ESIDB Comments on additional information/submissions received by D3

9.34 Fen Meadow Plan Report 1 Baseline Report - Part 1 of 2 - Revision 1.0 [REP3-051] and 9.34 Fen Meadow Plan Report 1 Baseline Report - Part 2 of 2 - Revision 1.0 [REP3-052]

DRAWING TITLE:
 FEN MEADOW - HALESWORTH
 WORKS PLANS - SHEET 12 OF 28

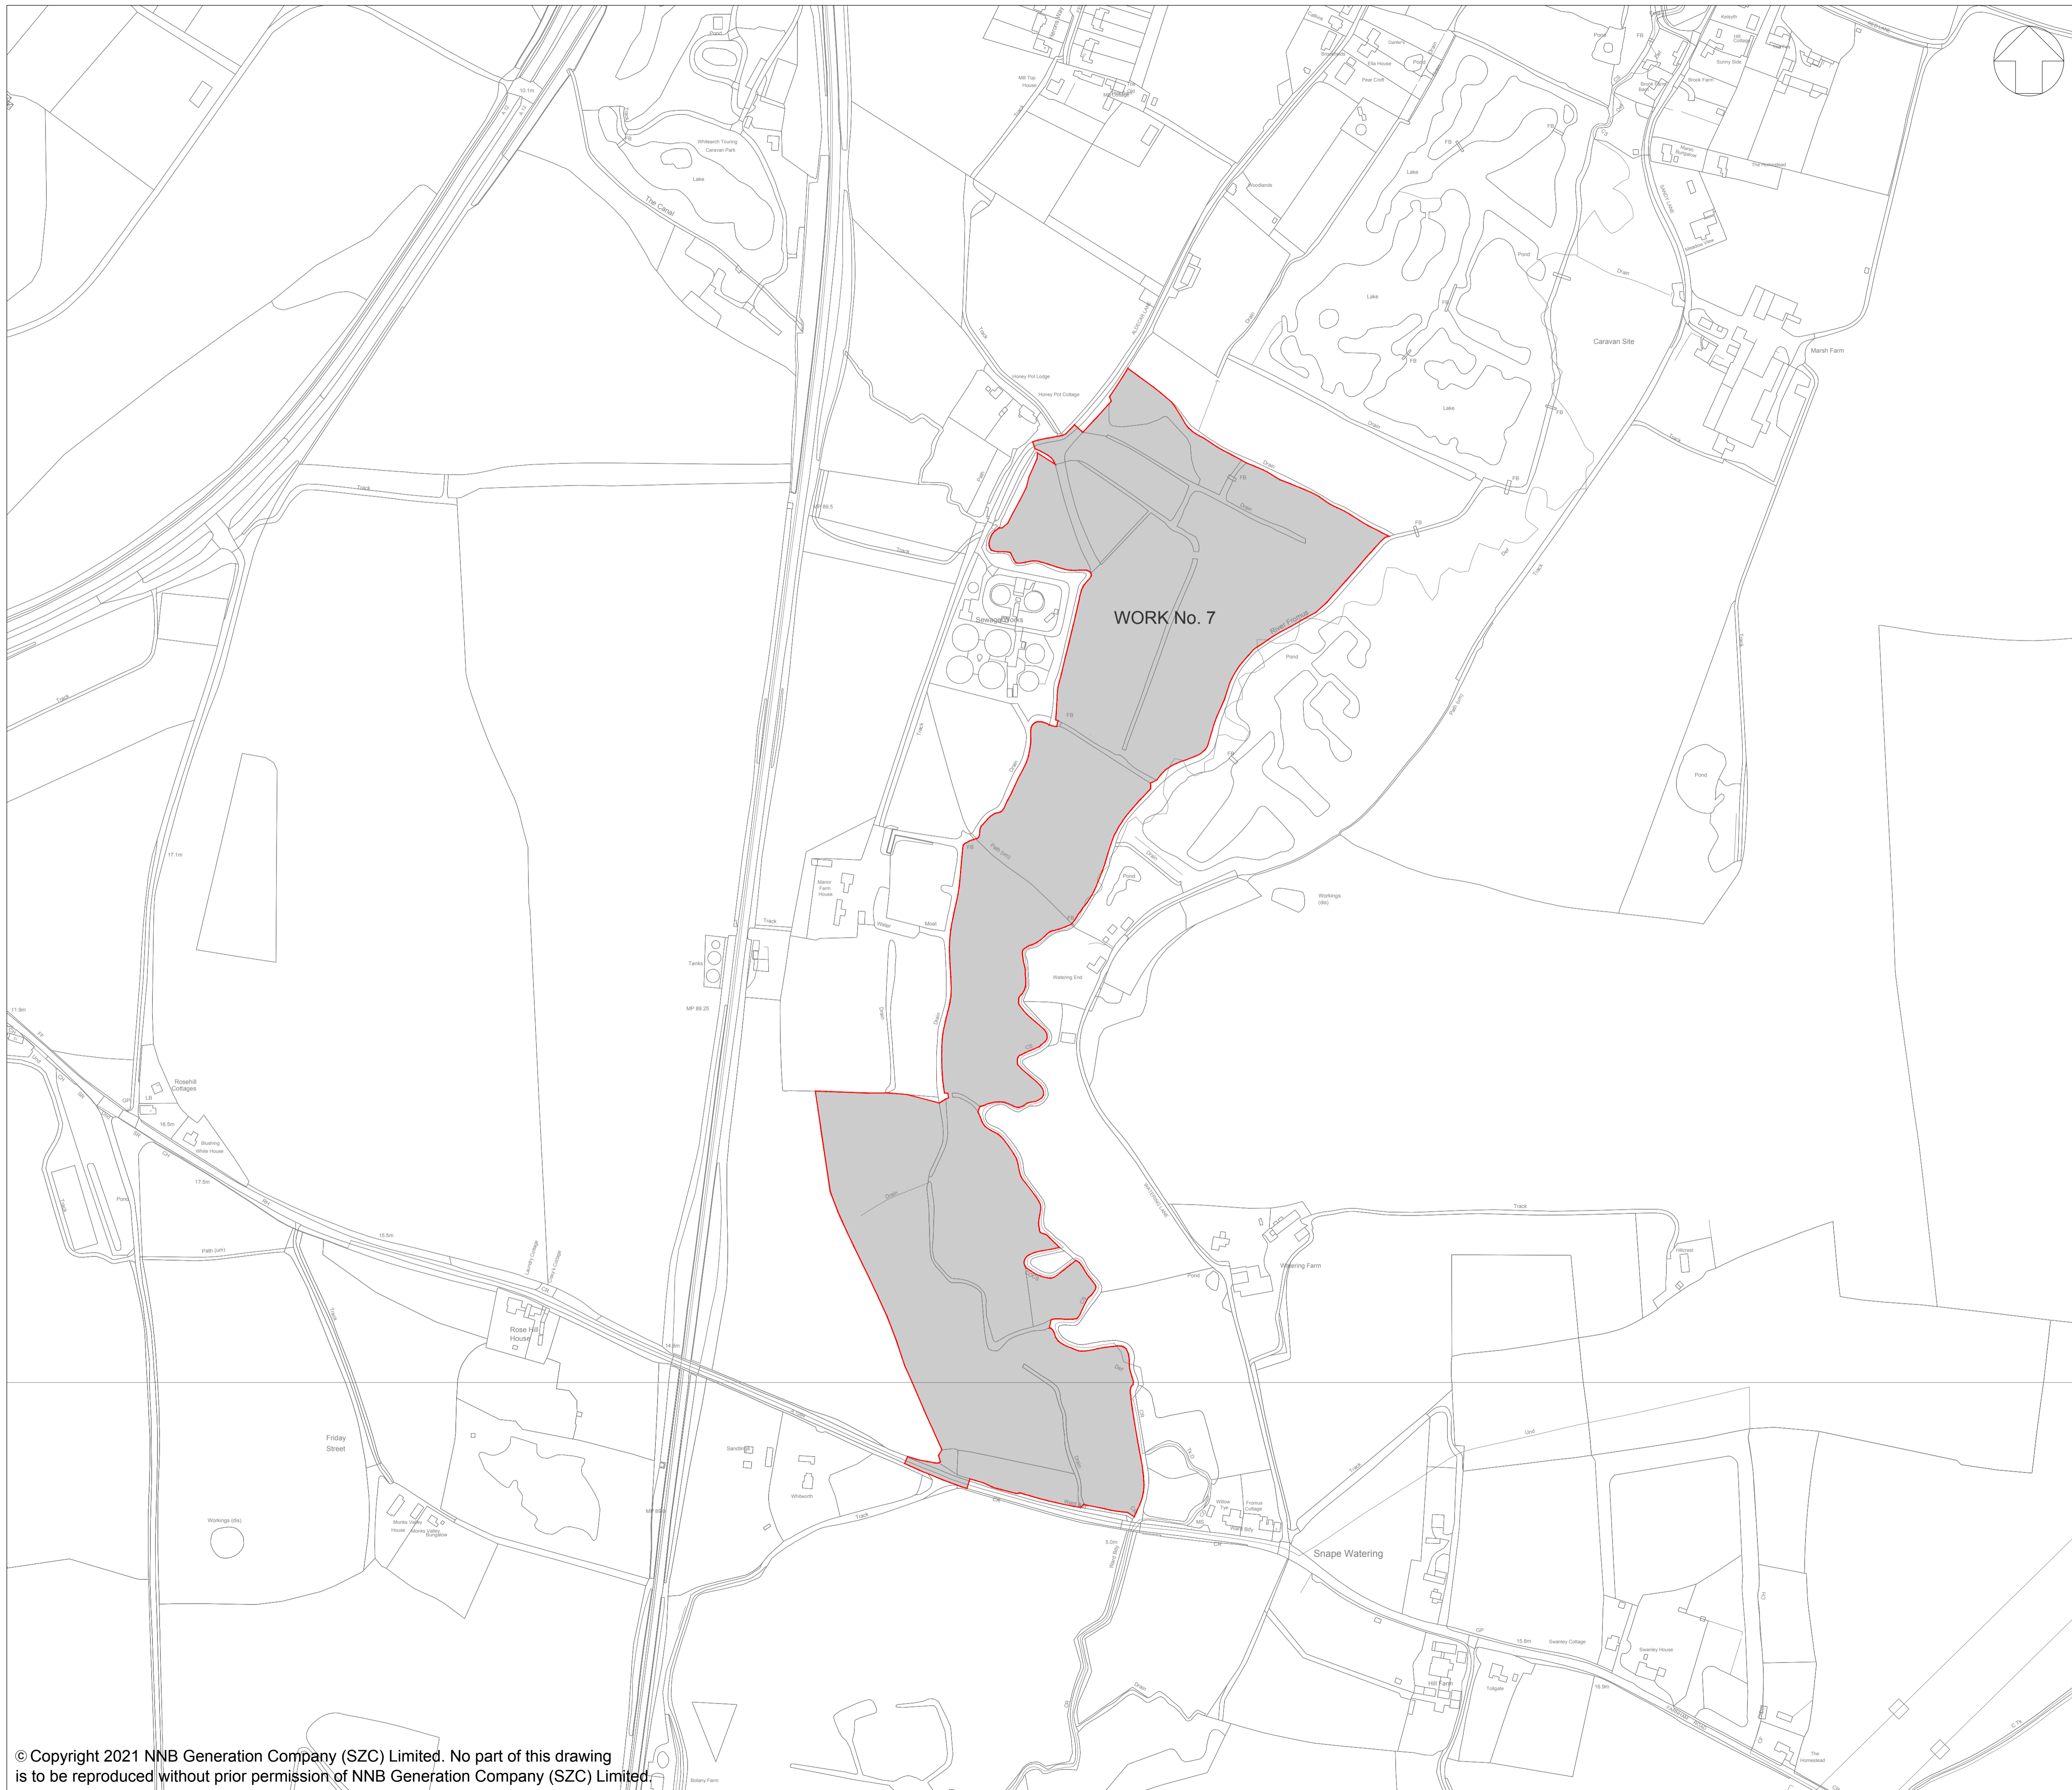
While the report correctly identifies that LLFA, District Councils and IDBs carry out flood risk management work on ordinary watercourses it erroneously indicates that there are no ordinary watercourses on the Halesworth and Pakenham sites. In accordance with the Land Drainage Act (section 72) *““watercourse” includes all rivers and streams and all ditches, drains, cuts, culverts, dikes, sluices, sewers (other than public sewers within the meaning of the Water Industry Act 1991) and passages, through which water flows”*. And an *““ordinary watercourse” means a watercourse that does not form part of a main river”*. Therefore the drainage ditches identified in 3.4.2 of the reports on each of the sites are under the authority of one of the above flood risk management authorities and as such any eventual water control structures placed within them will require Land Drainage Consent from the appropriate authority. In the case of Halesworth this authority is the ESIDB.
